## Application for a Non-Material Amendment Following a Grant of Planning Permission

Change of use from a removal business (Use Class E) to provide a hotel consisting of 11 bedrooms with ground floor coffee shop and dining room available for general public and for small conferences and events (Use Class C1 and E), erection of a single storey rear extension to provide kitchen, and erection of first floor extension to provide one additional bedroom with en-suite

23/03243/FUL

Relocation of the external walls to the first floor extension to create larger hotel room.

DRAWING TITLE
Proposed GA Plans - Level 01

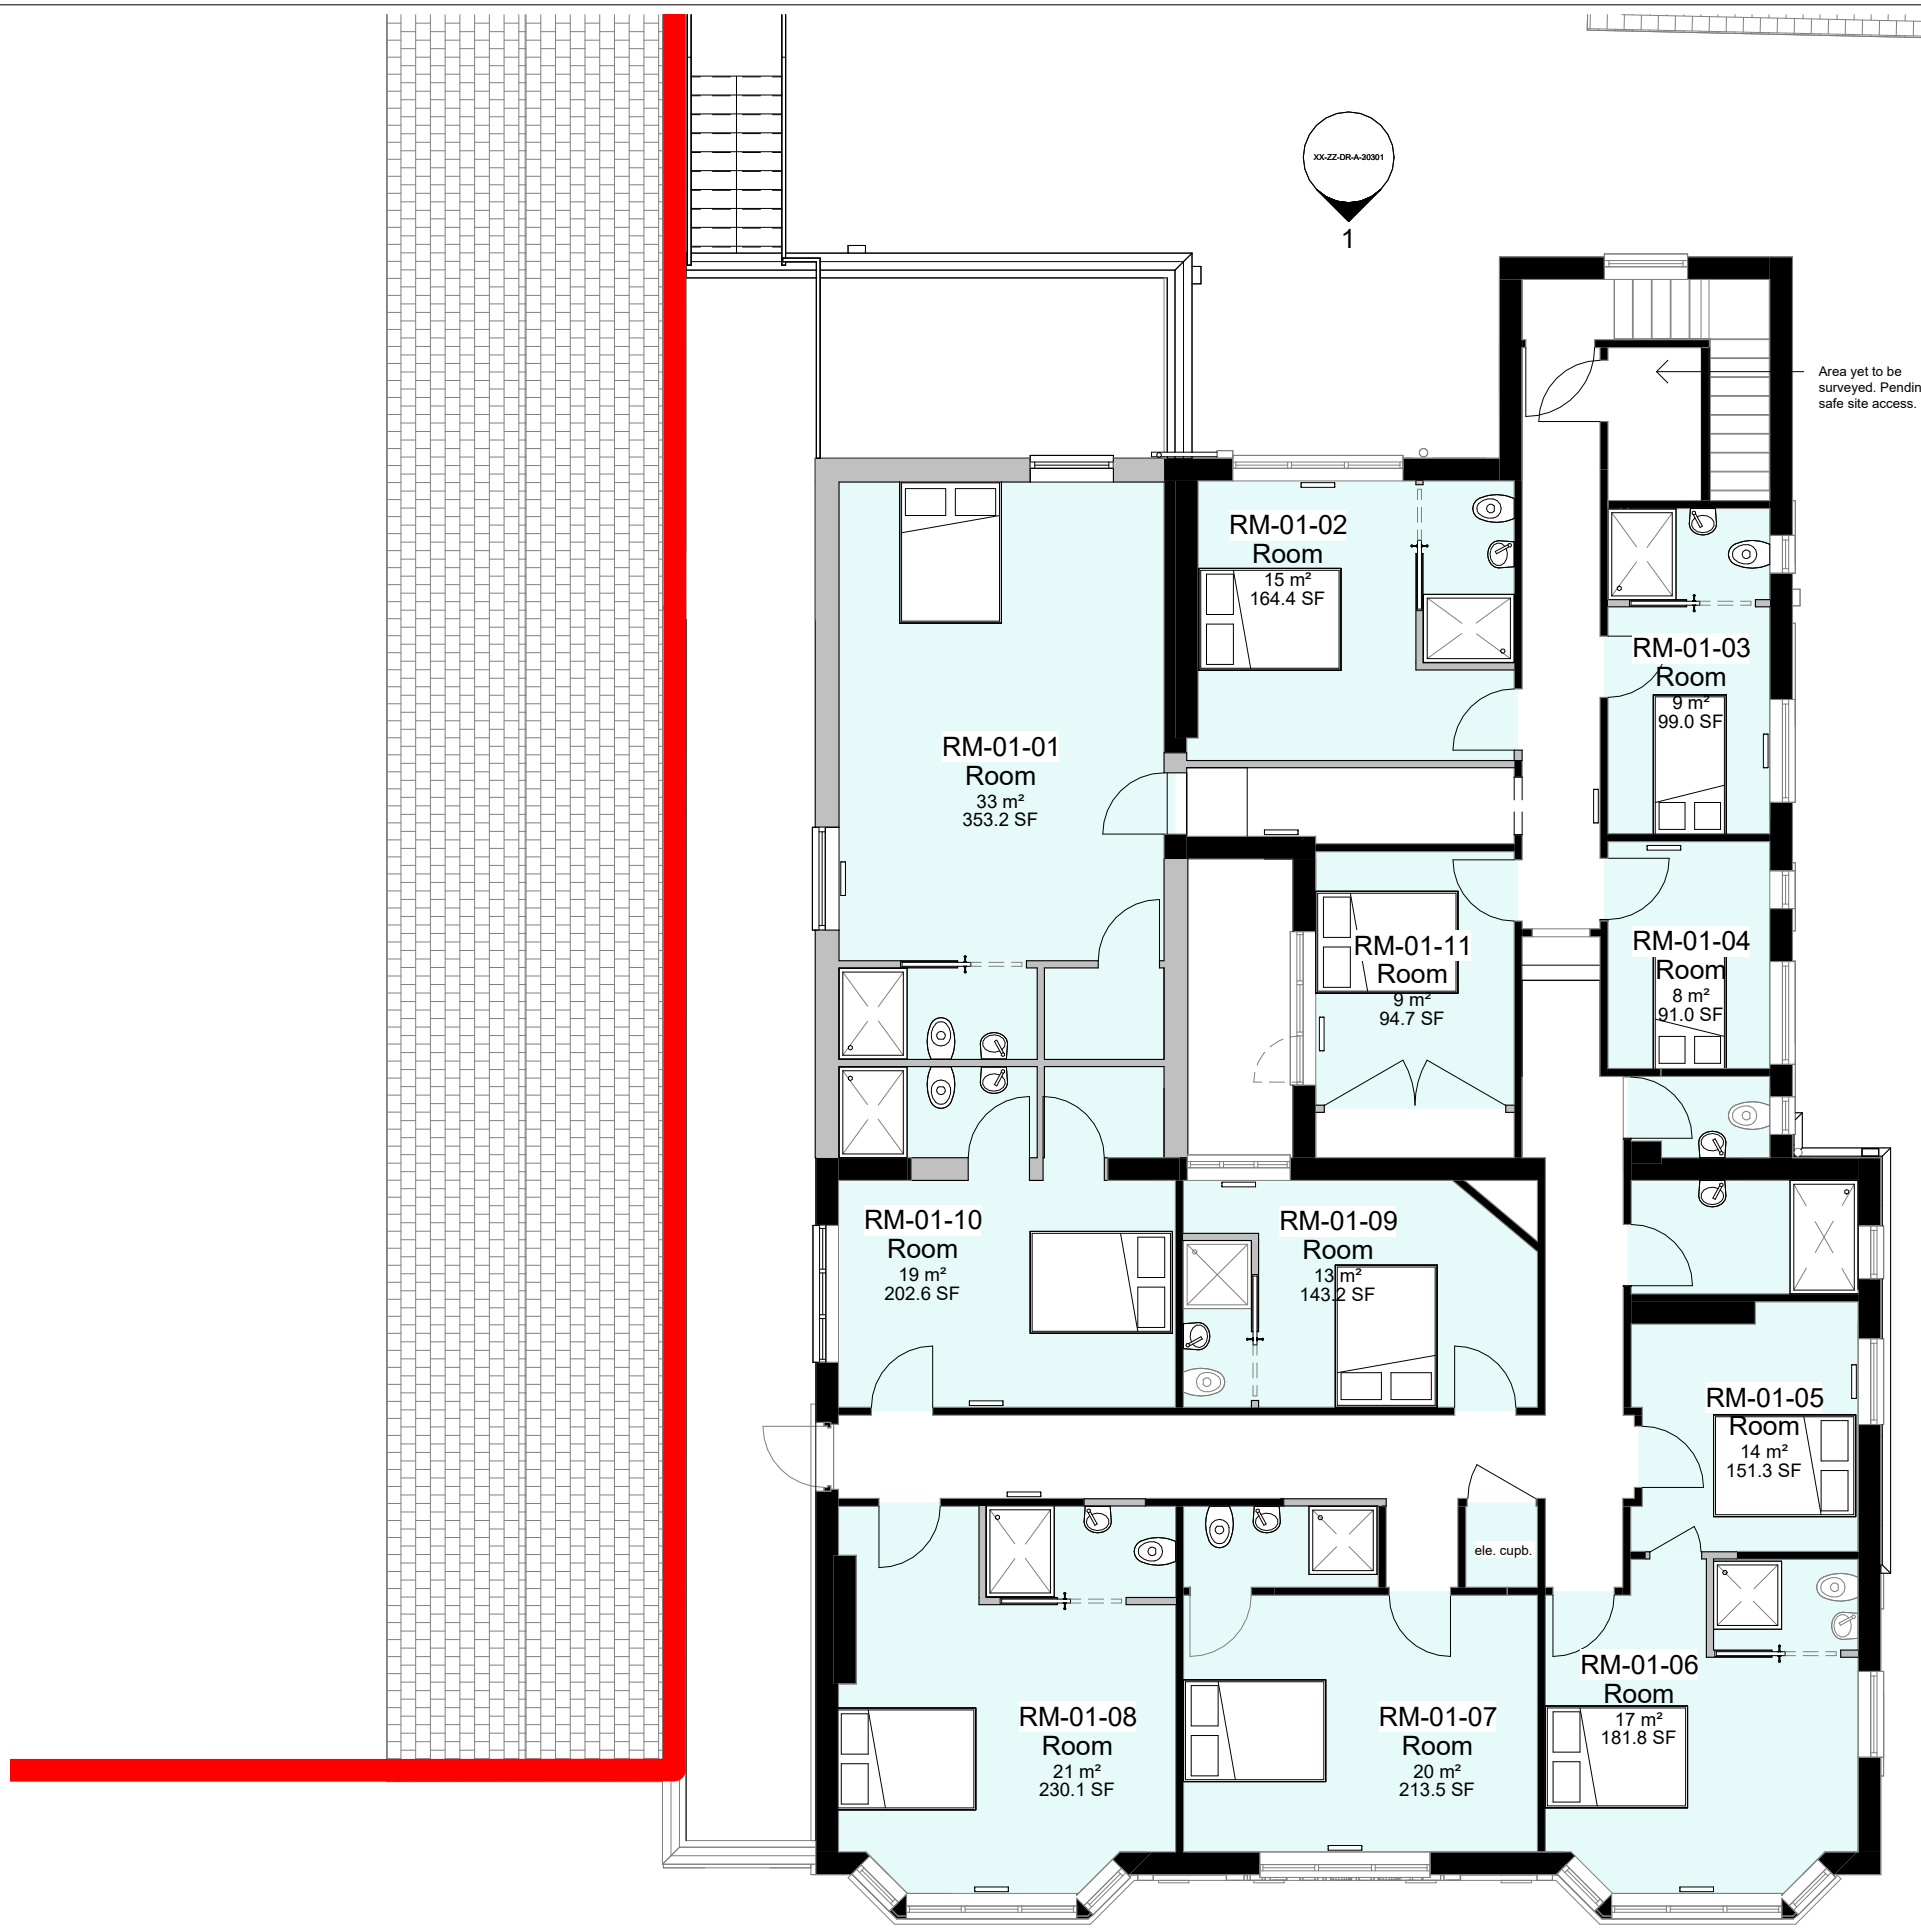
This design option would require much less structural steel work whilst also creating more comfortable/spacious internal environments.
